Our Case Number: ACP-323849-25

An
Coimisiún
Pleanála

Re: The proposed development is for a mixed use development that seeks the regeneration and adaptive reuse of a strategic brownfield site, as part of the Limerick City and County Council 'World Class Waterfront revitalisation and transformation project' 'Cleeves Riverside Quarter' in the townland of Farranshane More in Limerick City.

Formal Objection

16. Salesians Secondary School – Fernbank House c.1880 – Demolish with Mitigation

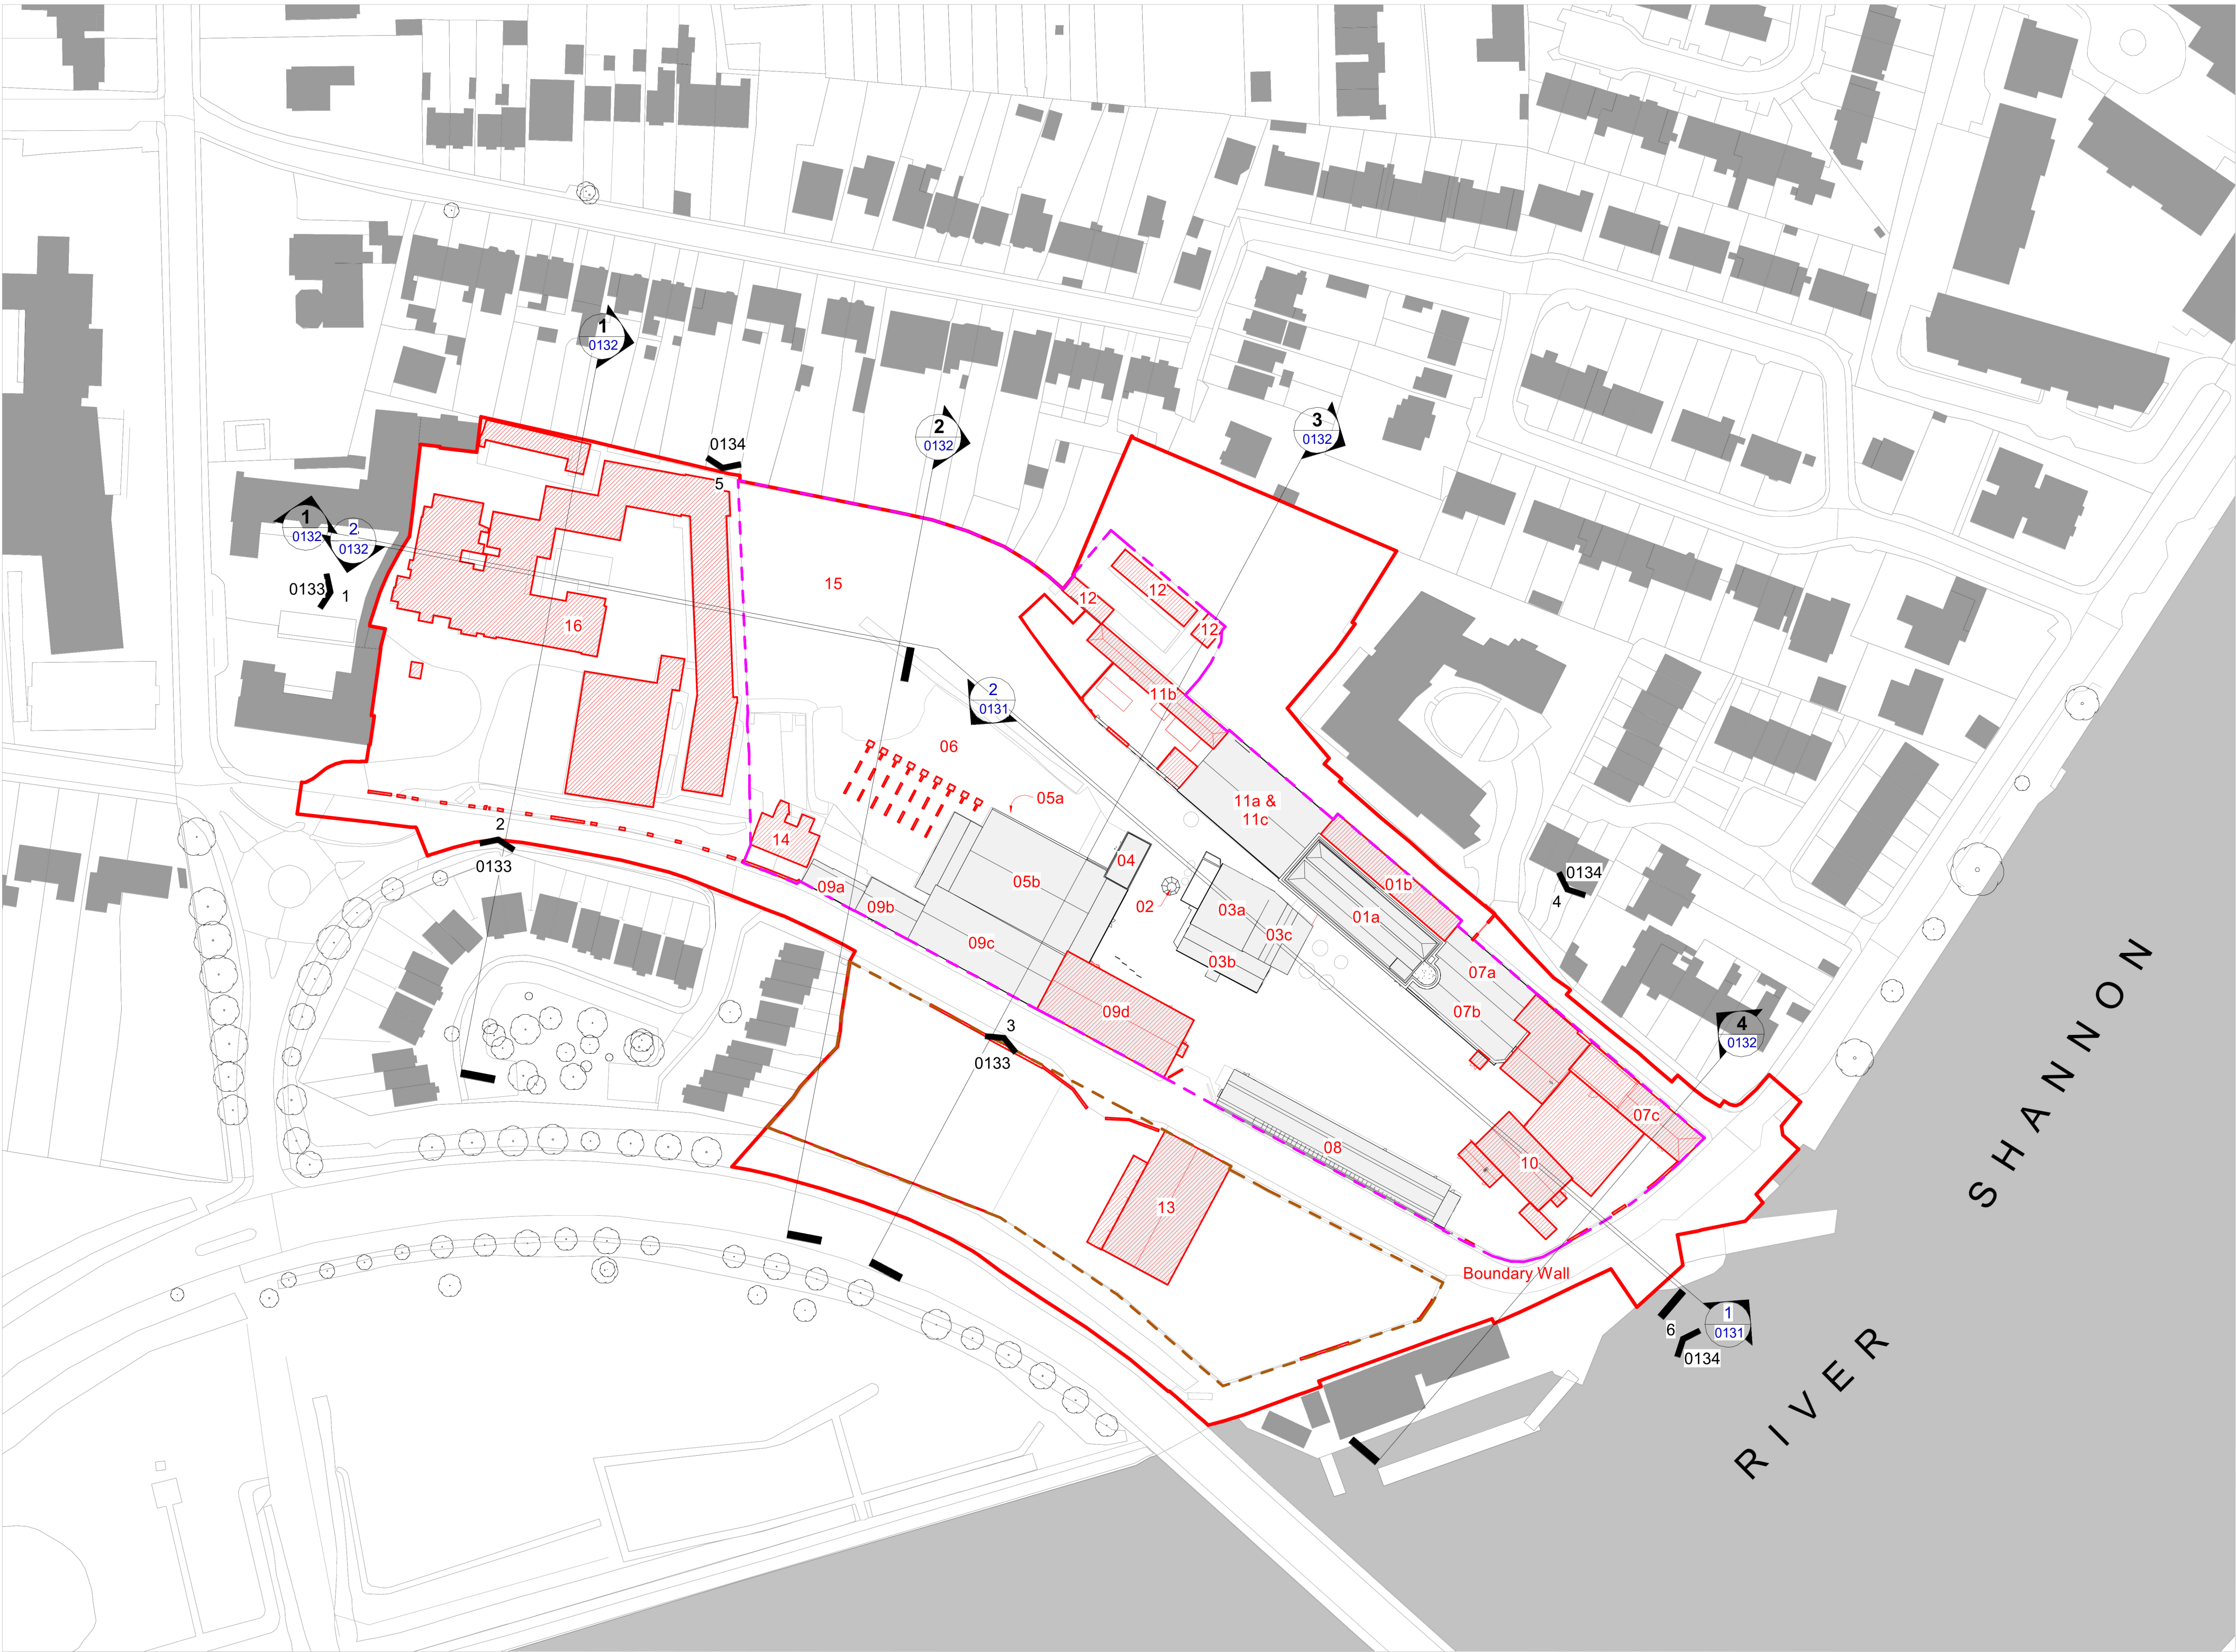
D. Failure to Preserve Fernbank House – Loss of Architectural and Social Heritage

Fernbank House is a mid-19th century NCR villa, historically linked to the Cleeve family and Salesian Sisters (1924–present), with intact original features.

The applicant acknowledges its importance but provides no conservation plan.

Contrary to:

- **Objectives BHA O1, O4, O6**
- Architectural Heritage Protection Guidelines (2011)
- *Balz v ABP* [2019] IESC 90

1. Full Conservation Report
2. No demolition/alteration without evidence-based justification
3. Retention and adaptive reuse
4. Refusal if no credible conservation plan
